Light Valley Solar

Written Summary of Applicant's Oral Submissions

Issue Specific Hearing 1

Document Reference: EN0110012/APP/LVS/08.08

Drawing Title
Figure 11.2
Environmental Sound Survey and Assessment Locations
Sheet Number 1 of 9

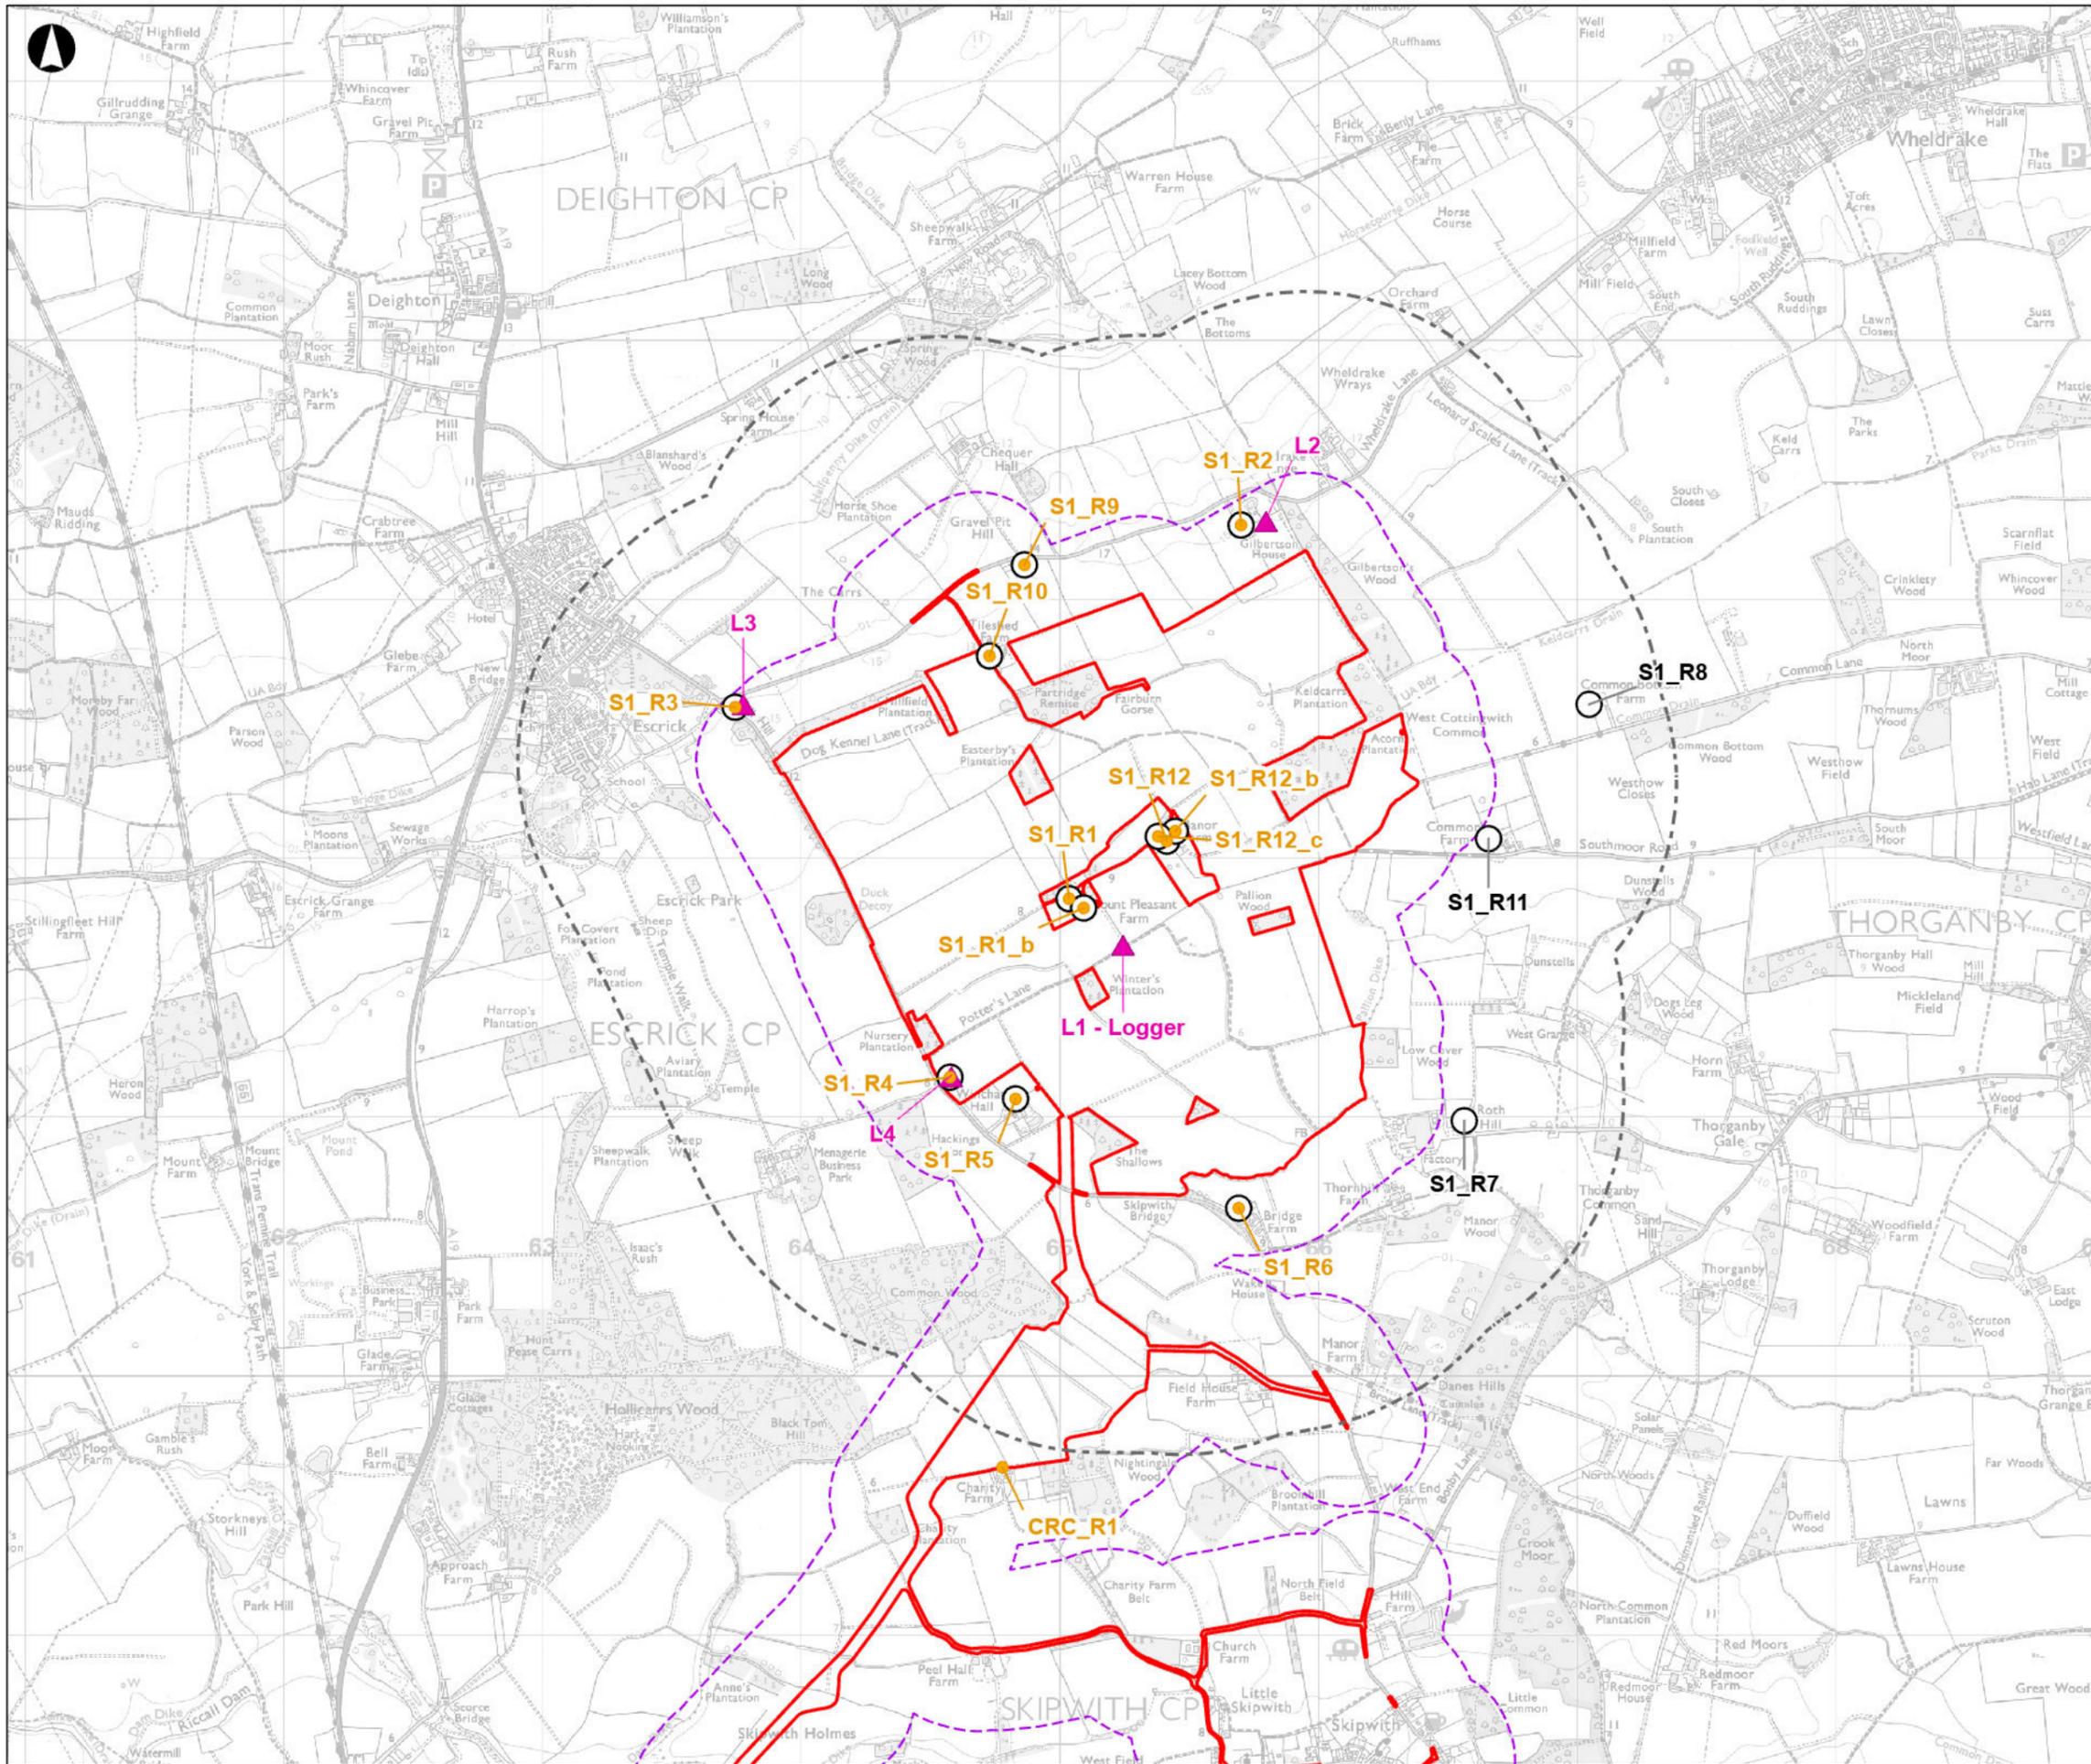
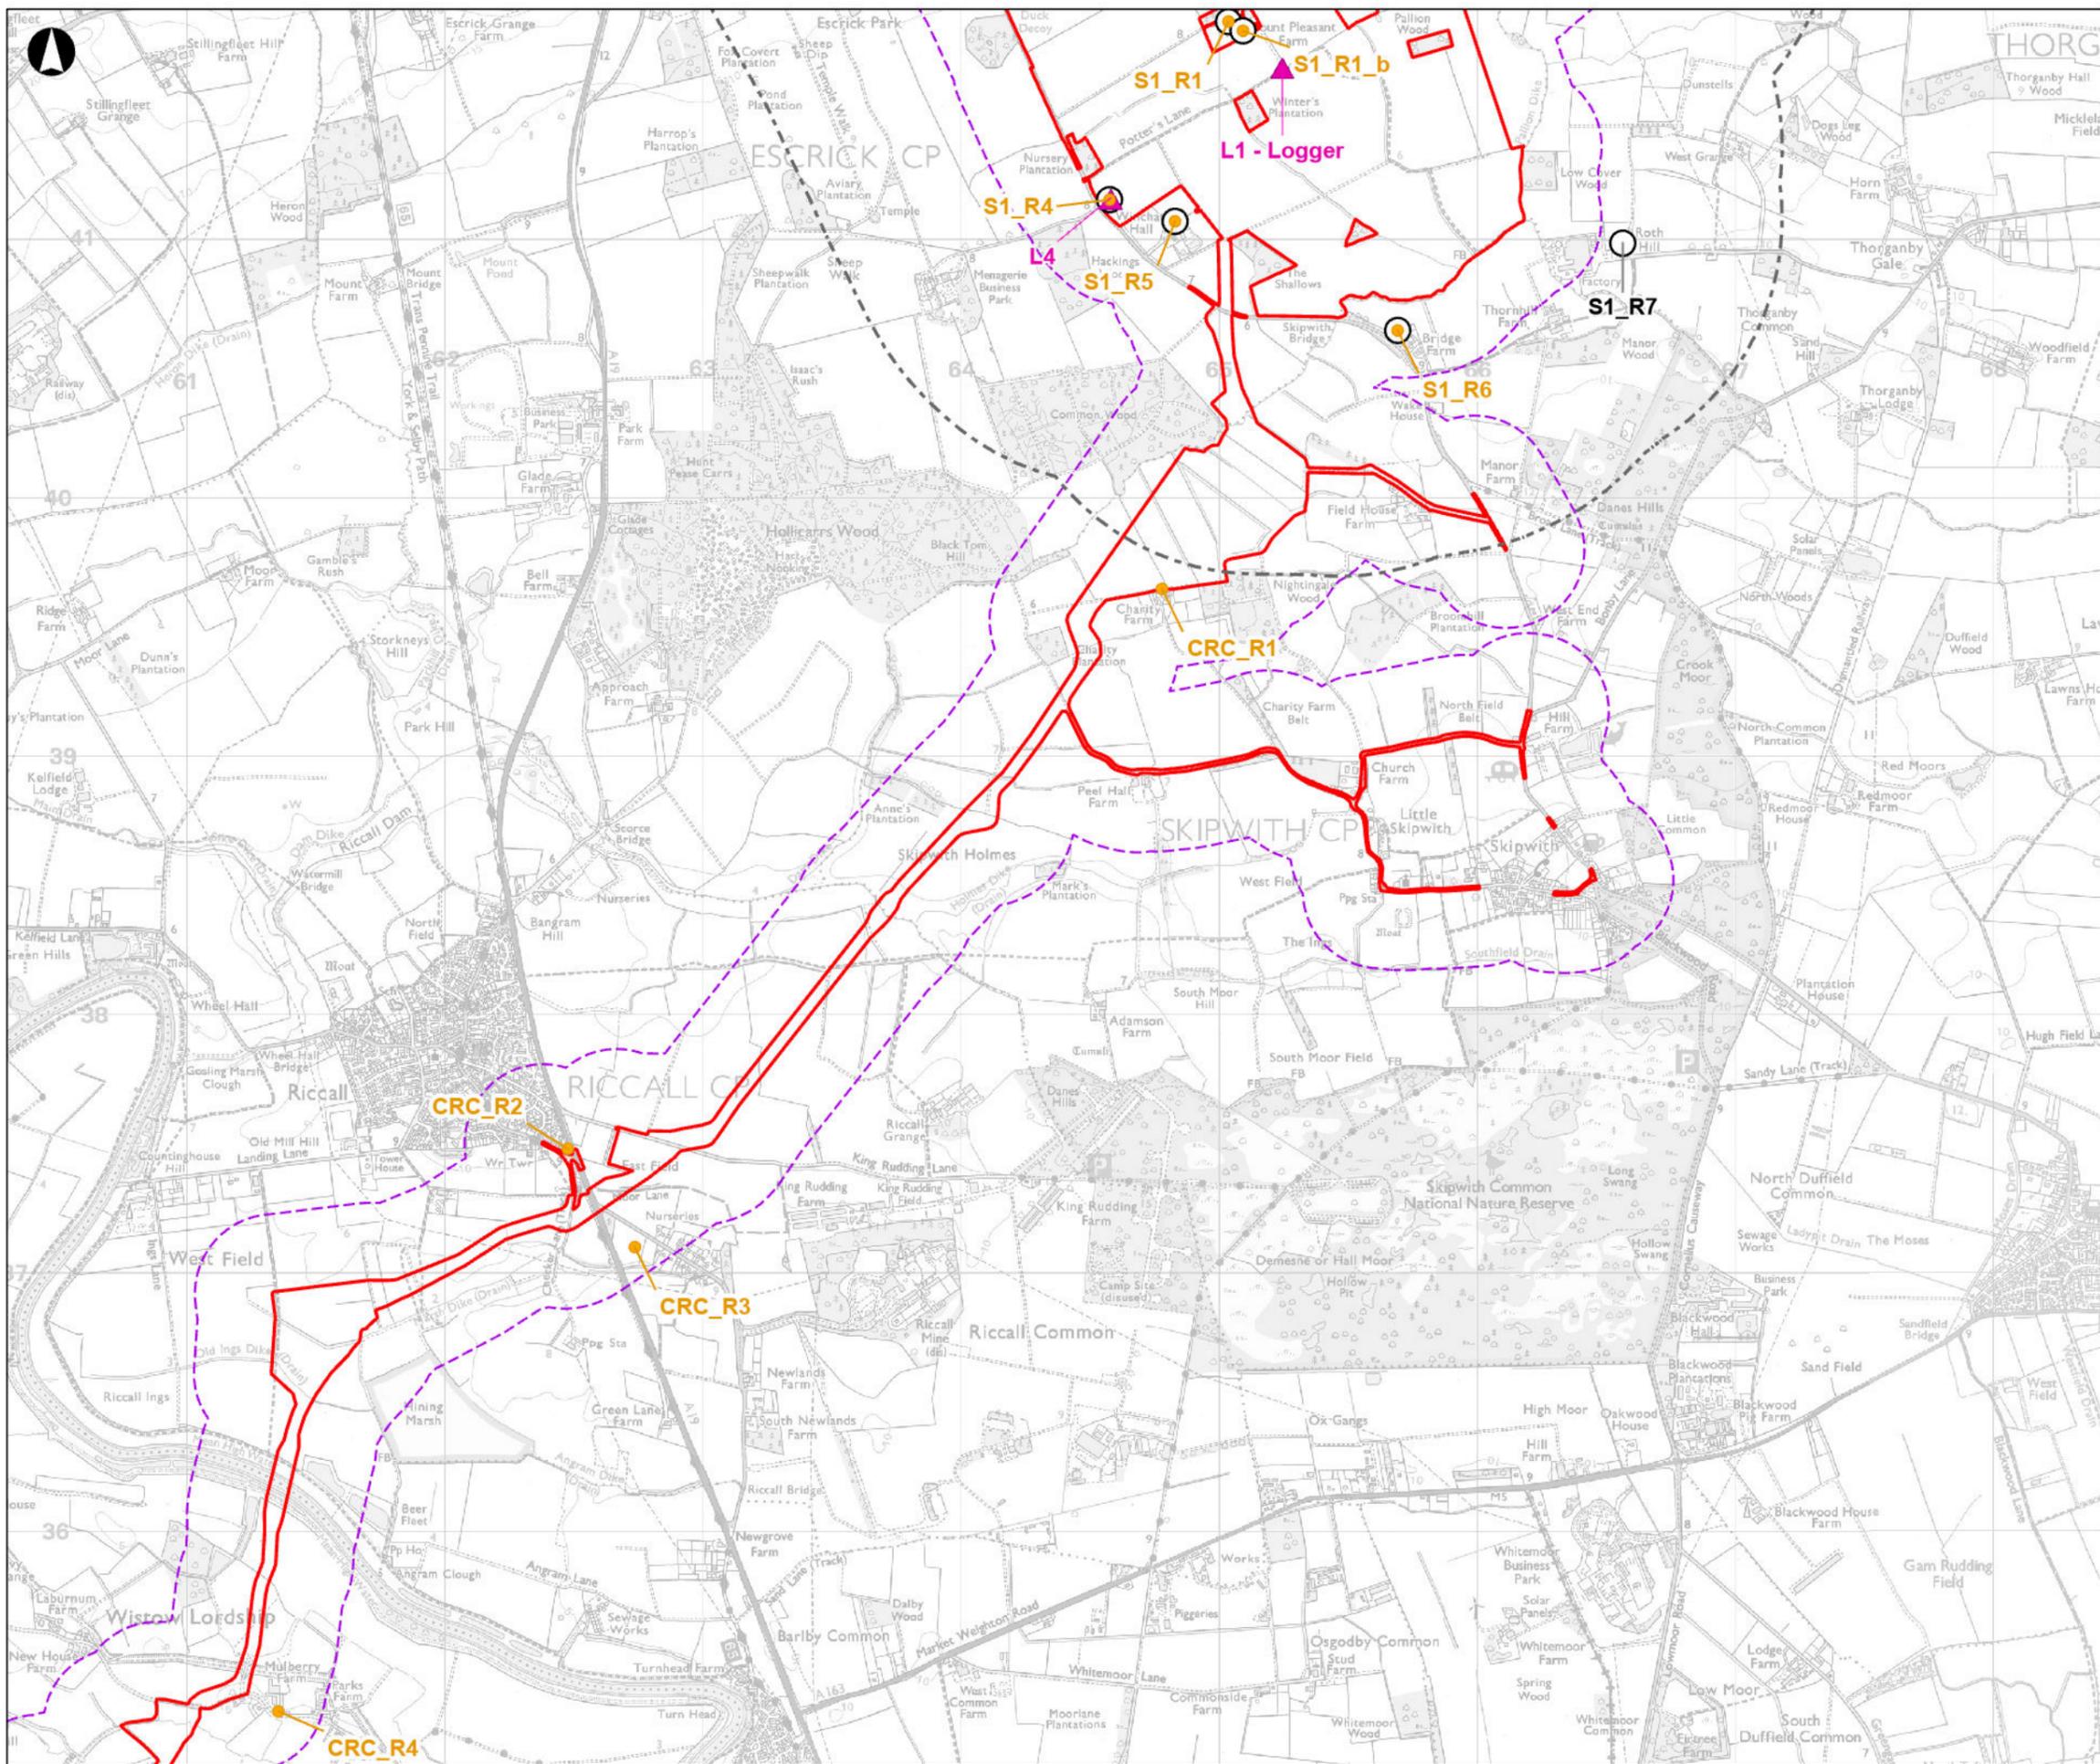
#	Agent Item	Written Summary of the Applicant's Oral Submissions
		<u>Tonality</u> The ExA asked the Applicant to explain the following: ▪ How residential receptors have been assessed with reference to Appendix 11.3 [APP-173]; ▪ How the characteristics of tonality, intermittency, and impulsiveness have been considered within the assessment; ▪ Whether those characteristics could materially alter the perceived impact on nearby receptors; and ▪ How the applicant proposes to introduce future controls on operational noise at residential receptors. <u>Assessment methodology</u> In respect of the sound level, Mr Hiller confirmed that 91dB mentioned at the Open Floor Hearing is from Table 2.1 of ES Appendix 11.3 [APP-173] and this is a sound <u>power</u> level. The Applicant explained that sound power levels characterise the output of a source. Those levels are inputted into three-dimensional noise mapping software which then predicts the sound levels arising from the site at all assessed receptors. These calculations are then interrogated to show the likely noise <u>impacts</u>. Mr Hiller confirmed that the assessment of operational noise has been carried out in accordance with British Standard 4142 (Methods for rating and assessing industrial and commercial sound), which is the appropriate standard for noise sources of a commercial or industrial character. This is applied to building services plant and associated equipment. He submitted that this standard is equally applicable to the sources proposed in the Proposed Development. The approach involves comparing the predicted noise from the plant against the background sound level at each receptor, assessed separately for daytime and night-time conditions. Baseline sound levels have been established from an environmental sound survey using noise loggers deployed at

#	Agent Item	Written Summary of the Applicant's Oral Submissions
		various locations, illustrated in Figure 11.2 of the Environmental Statement [APP-099]. The tabulated impact assessments following the BS 4142 methodology are set out in ES Appendix 11.3 [APP-173]. Mr Hiller confirmed that the Applicant had assumed a 4 dB correction (tonality penalty) for the predicted sound levels from all assessed equipment. This penalty is taken from British Standard 4142 and is representative of what the standard describes as "clearly perceptible tonality" in the sound as perceived at the receptor. Intermittency in this aspect would not be relevant as the equipment will operate in a continuous manner whilst running, rather than switching rapidly on and off over short time periods. Accordingly, an intermittency correction has not been applied. Moreover, Mr Hiller explained that tonality affects people's perception of sound without necessarily producing a higher absolute noise level. By applying the tonality penalty when calculating the rating level, the assessment produces a more representative evaluation of the impact on people's perception of the noise, rather than relying solely on the raw sound level. The Applicant did not identify impulsiveness as a characteristic applicable to the operational noise sources in this development. No impulsiveness correction has been applied. <u>Future controls on Operational Noise</u> The applicant acknowledged that the level of control that can be applied to tonality cannot be fully assessed until the individual items of plant are understood in detail. For the purposes of the assessment, it has been assumed that tonality may or may not be perceptible at receptors. There are a number of sources for each of those so tonalities may or may not be perceptible as the noise from the sources may attenuate to the point where it is inaudible against the background soundscape. Mr Hiller noted that, for example attenuators could be fitted onto conversion units to reduce sound levels where needed. These can be used to control frequency content if necessary. Moreover, it has
